**APPLICATION BY SEMBCORP UTILITIES (UK) LIMITED FOR AN ORDER GRANTING DEVELOPMENT CONSENT FOR THE TEES CCPP PROJECT WRITTEN REPRESENTATIONS BY THE ENVIRONMENT AGENCY.**

## Tees CCPP DCO Application Planning Inspectorate Reference: EN010082

### Written Representations On behalf of the Environment Agency

**Figure E3.1** *Modelled NO<sub>x</sub> Concentrations*

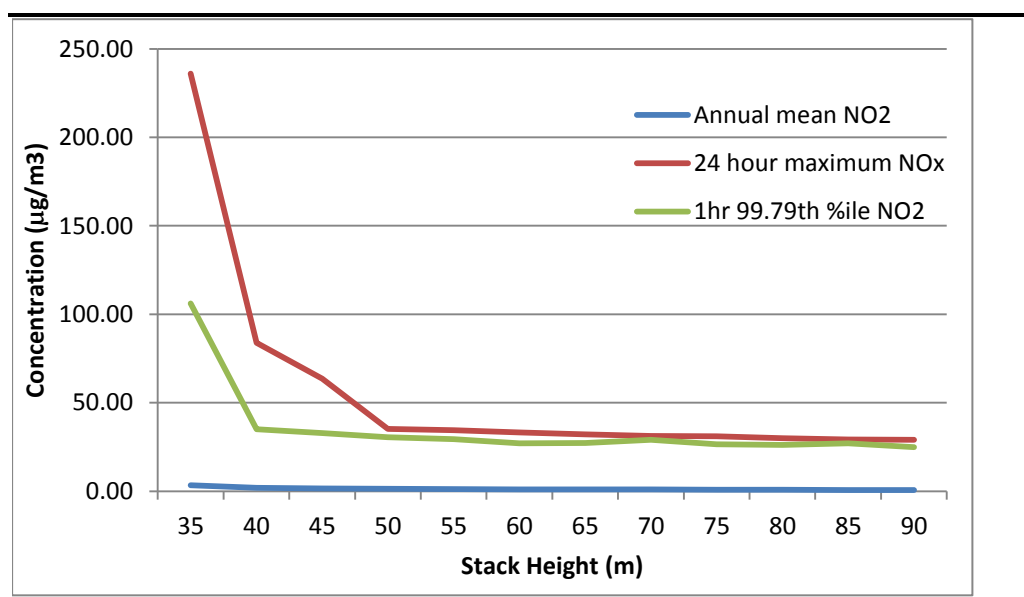
Air impact modelling data for a minimum stack height of 75m and maximum stack diameter of 8m has been submitted.

The applicant has not considered the technical feasibility of reducing the stack diameter to aid environmental monitoring of emissions, and to increase the exit velocity from the stack to improve dispersion. Emissions from the site must be controlled to levels which are below the relevant exposure criteria which are protective of human health and the environment. This issue must be addressed in the DCO.

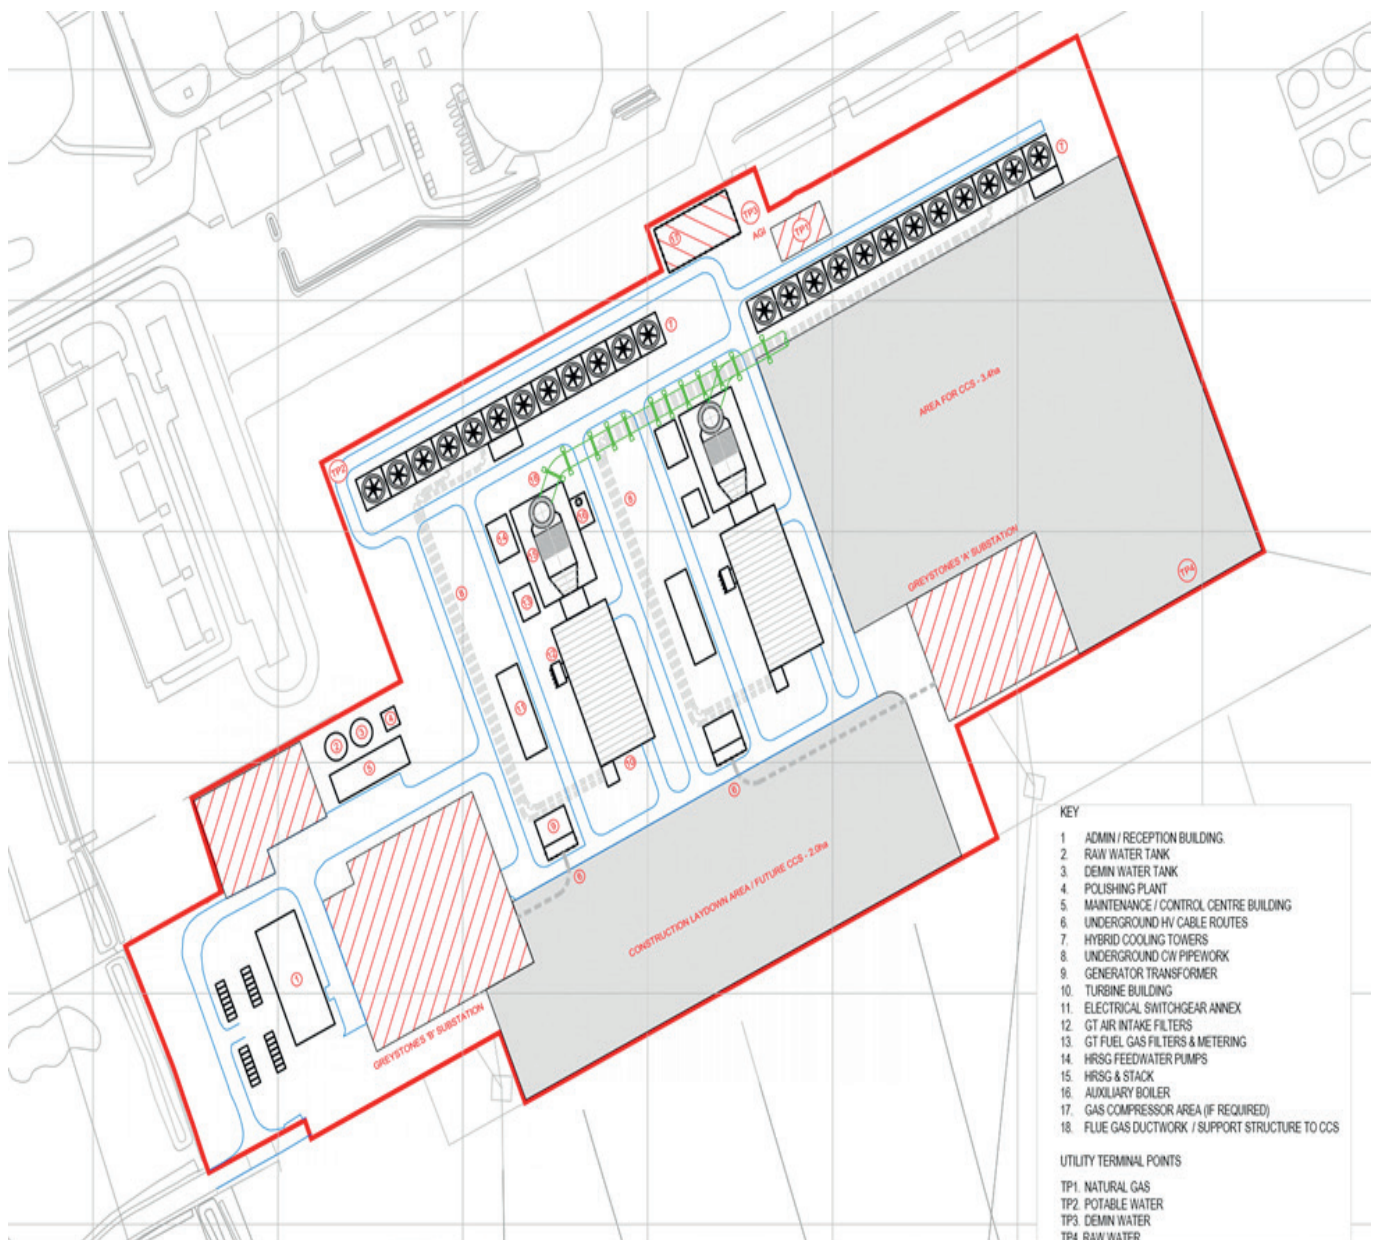
The applicant has NOT provided sufficient information to demonstrate whether there is sufficient space to accommodate the carbon capture plant (CCP) and whether it is technically feasible to retrofit the carbon capture technology selected.

Despite this change in guidance, the EA considers that the space currently allocated to the carbon capture plant is too small. Therefore, the applicant will need to set aside further land **or** provide detailed evidence that the CCP could be accommodated in the space allocated. This may be difficult to demonstrate given that the current guidance (Florin and Fennel 2010) shows that even with detailed engineering design, the space required could only be reduced to 6.5 Ha, and not to the 5.4 Ha proposed by the applicant.

The applicant should submit the information required by the form “Environment Agency verification of CCS Readiness New Natural Gas Combined Cycle Power Station Using Post-Combustion Solvent Scrubbing”, as outlined in Annex C of the Department of Energy and Climate Change (DECC) (2009) Carbon Capture Readiness guidance, for assessment.

The applicant should reconsider the space allocated to CCP, and either increase the allocated plot size, **or** provide detailed evidence that the CCP will be able to be accommodated within the space allocated.
